Application for removal or variation of a condition following grant of  
planning permission. Town and Country Planning Act 1990.  
Planning (Listed Buildings and Conservation Areas) Act 1990

Change of use of premises from Class B8 to B1c/B2/B8, including internal and external alterations, demolition of ancillary structures and new access to Southam Road

18/01246/F

Vary Condition 2 - Drawing noted as P003 Rev U - replace drawing with P003 Rev V.

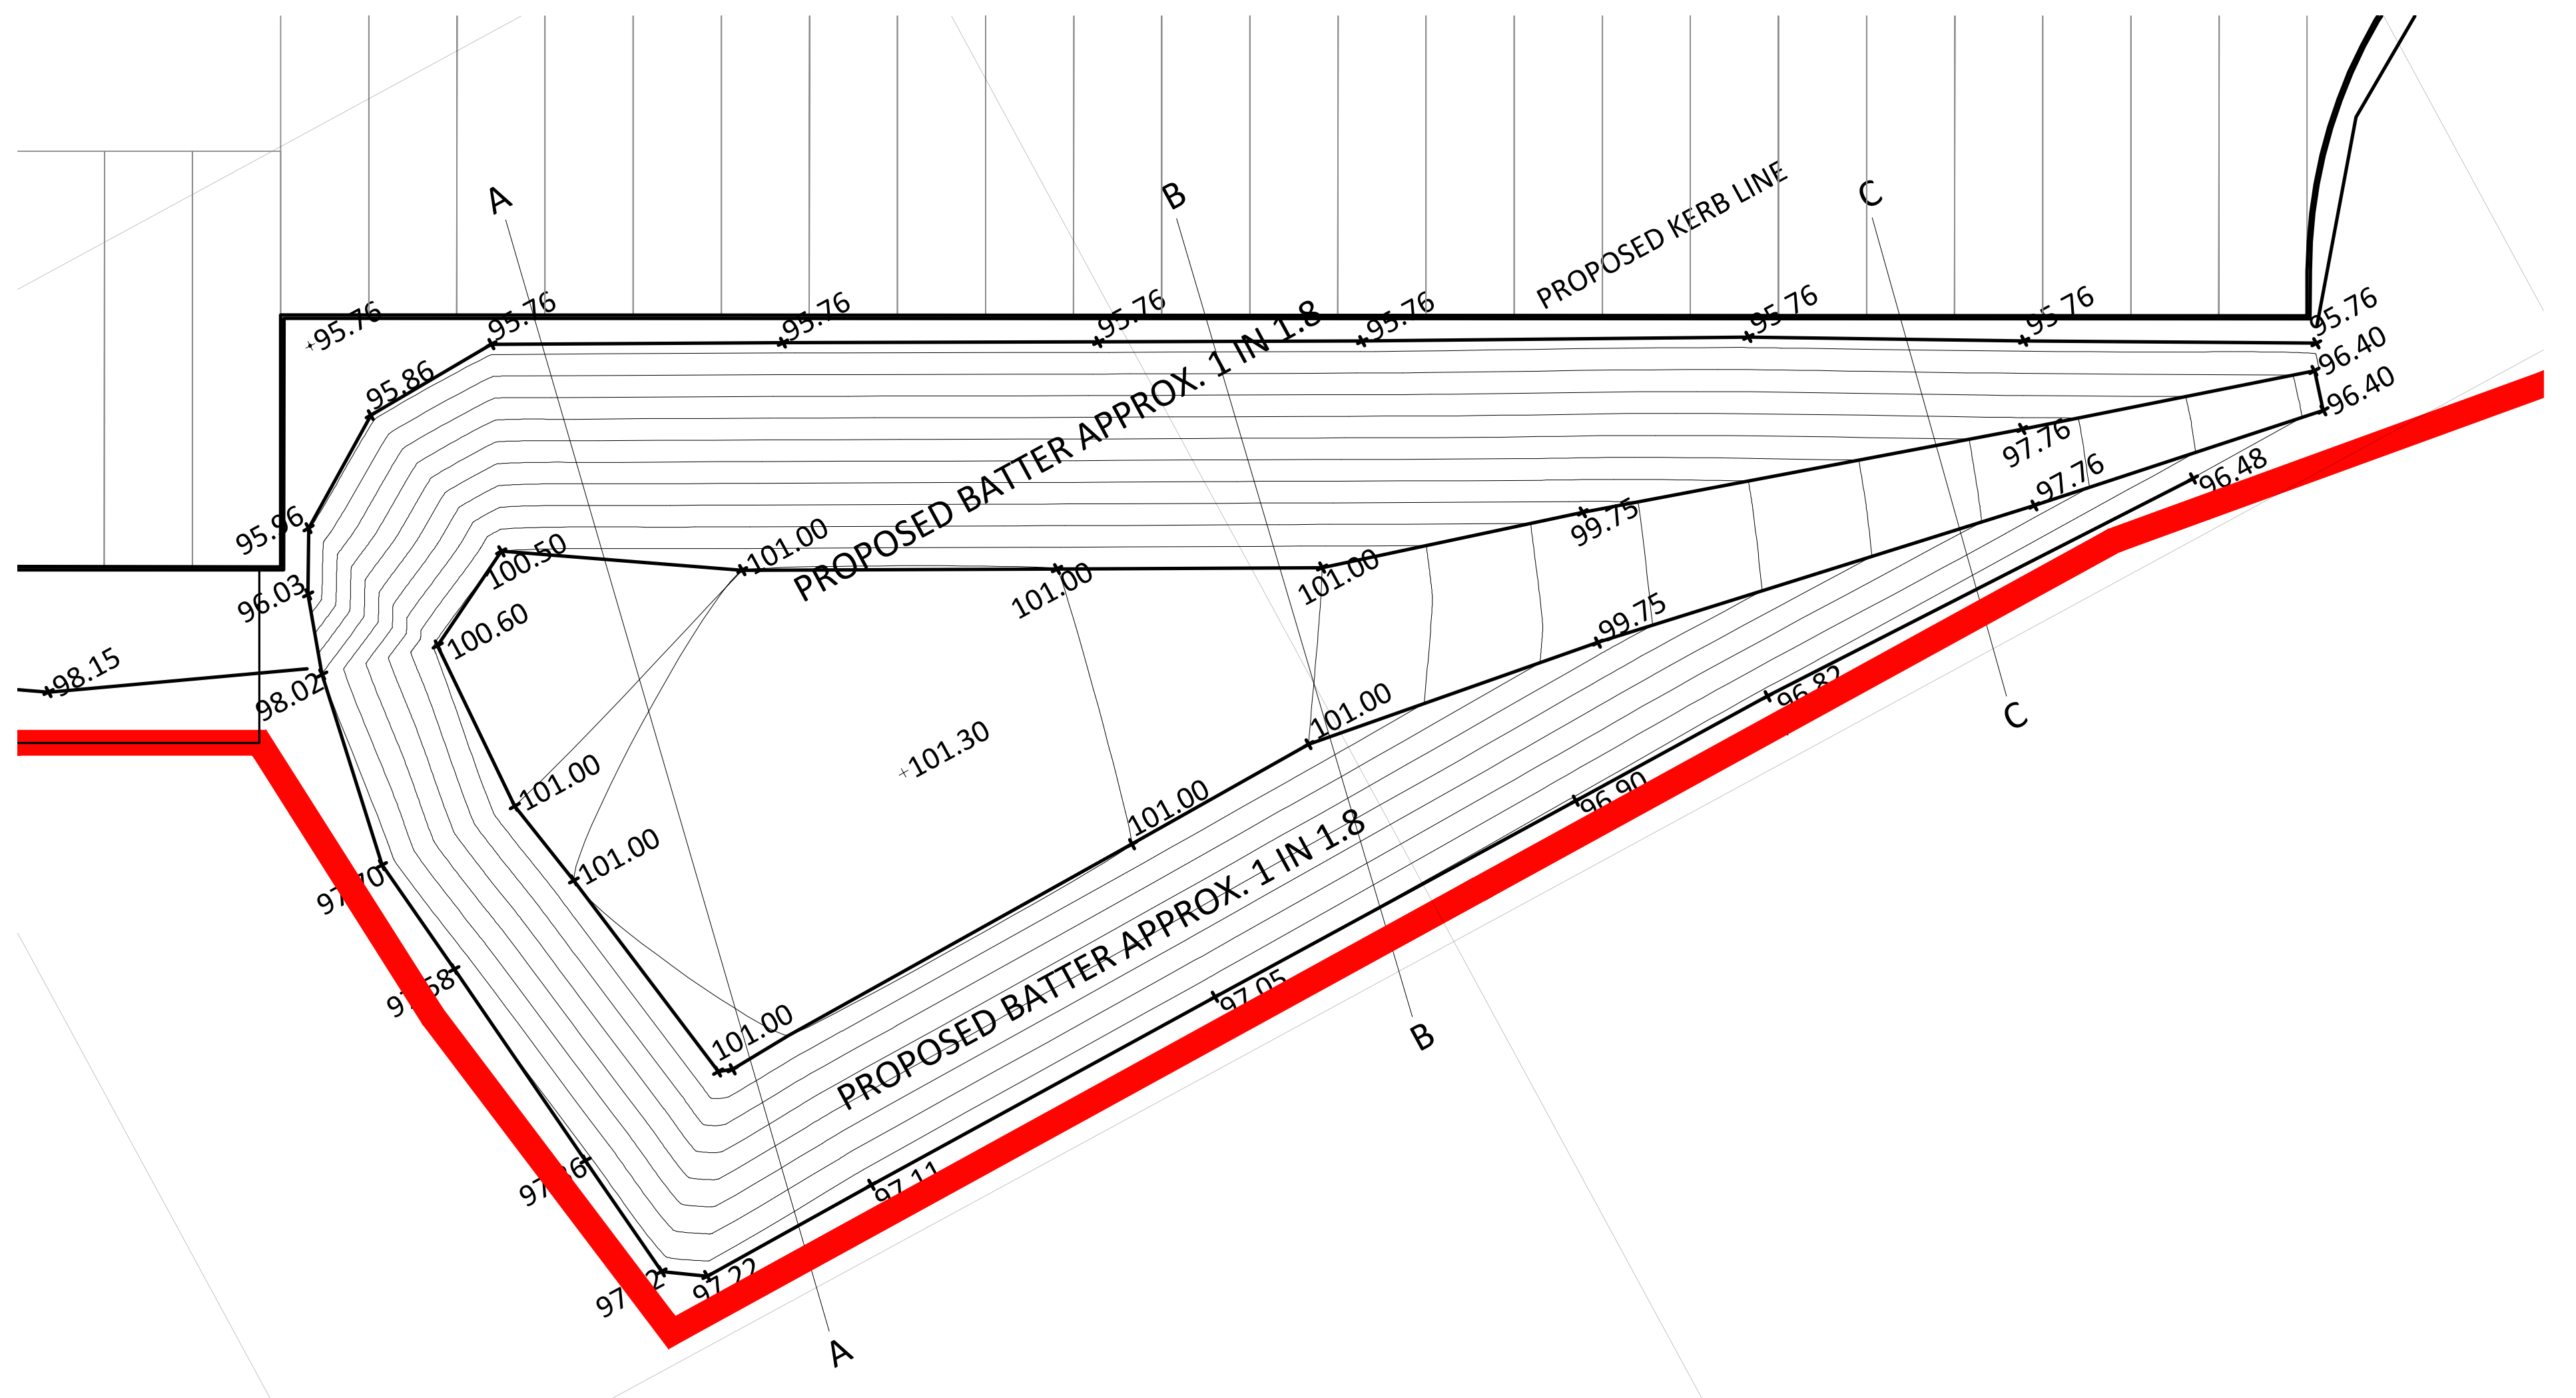
Addition of landscaped bund - additional details indicated on drawing 16083\_P022\_A\_Site Bund Plan & Sections
